# **APPENDIX 2**

## **Summary of Responses to** **Agency Submissions**

**SUMMARY OF AGENCY SUBMISSIONS**

Precinct 3 - Pemulwuy Mixed Use Development, REDFERN	
J:\02\00210 Pemulwuy Project\4 NIA Documentation\5 CAD\01 Dwg\01 Model\01 Current\02\00210_3DA Precinct 3_120417.rvt	
JOB No.	DEK00210
DATE	October 2010
SCALE	A1 @ As Indicated
DWG No.	3DA100 E

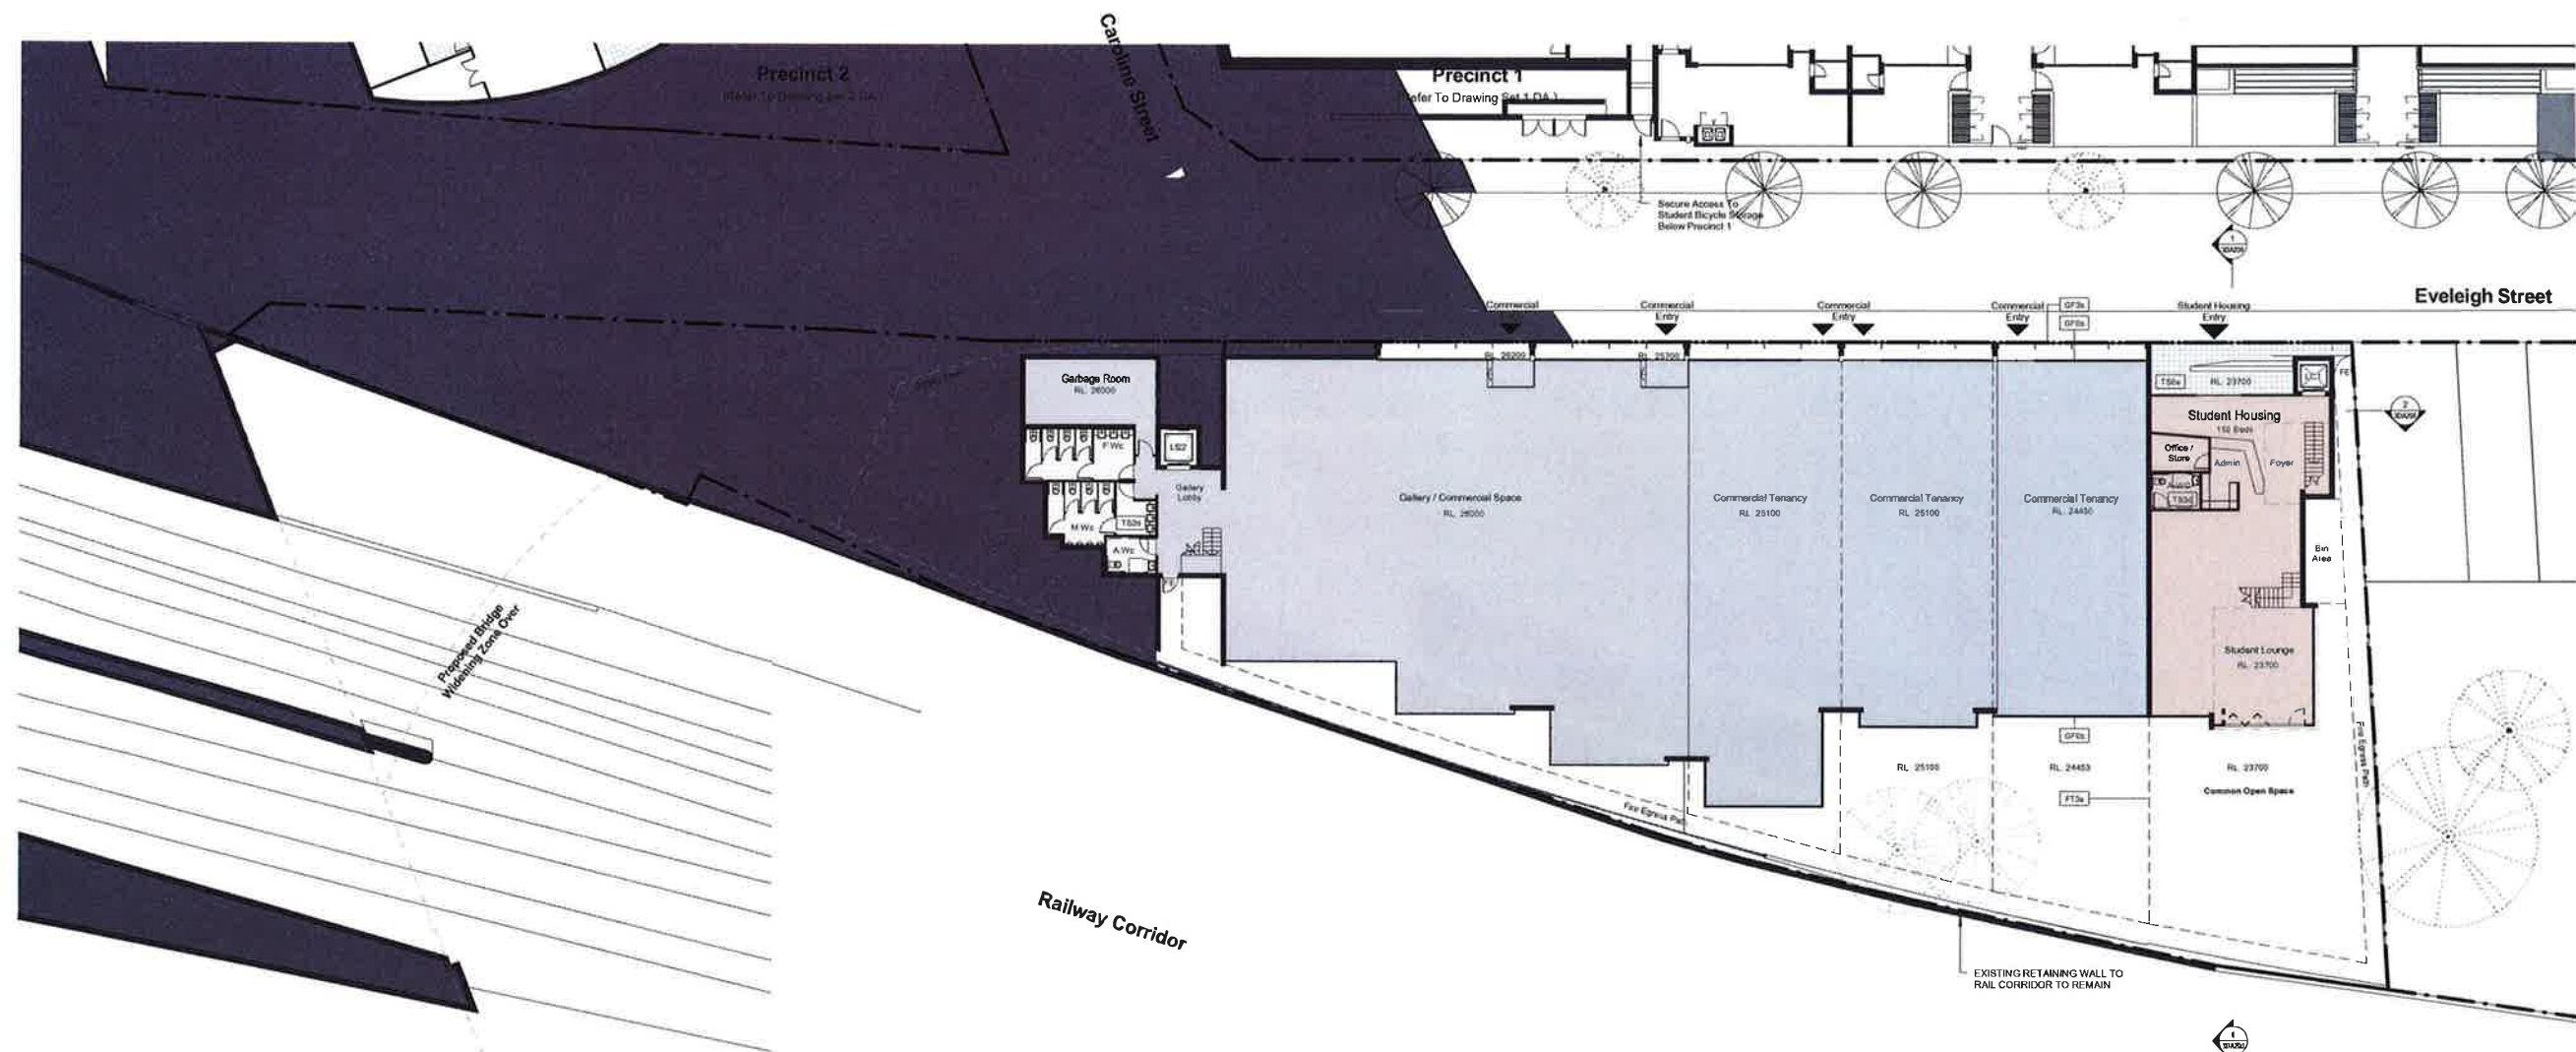
| Authority/Organisation Submissions |                                    |  |   |
|------------------------------------|------------------------------------|--|---|
|                                    |                                    | The private outdoor terraces shown on the landscape plan for Precinct 3 should be used as a landscaped common area for the student housing   | The outdoor terraces at the ground floor level in Precinct 3 are to be allocated to the student housing and the adjacent commercial space that they abut. The terrace associated with the student housing is to be for common use refer plan <b>3DA100[E]</b> .   |
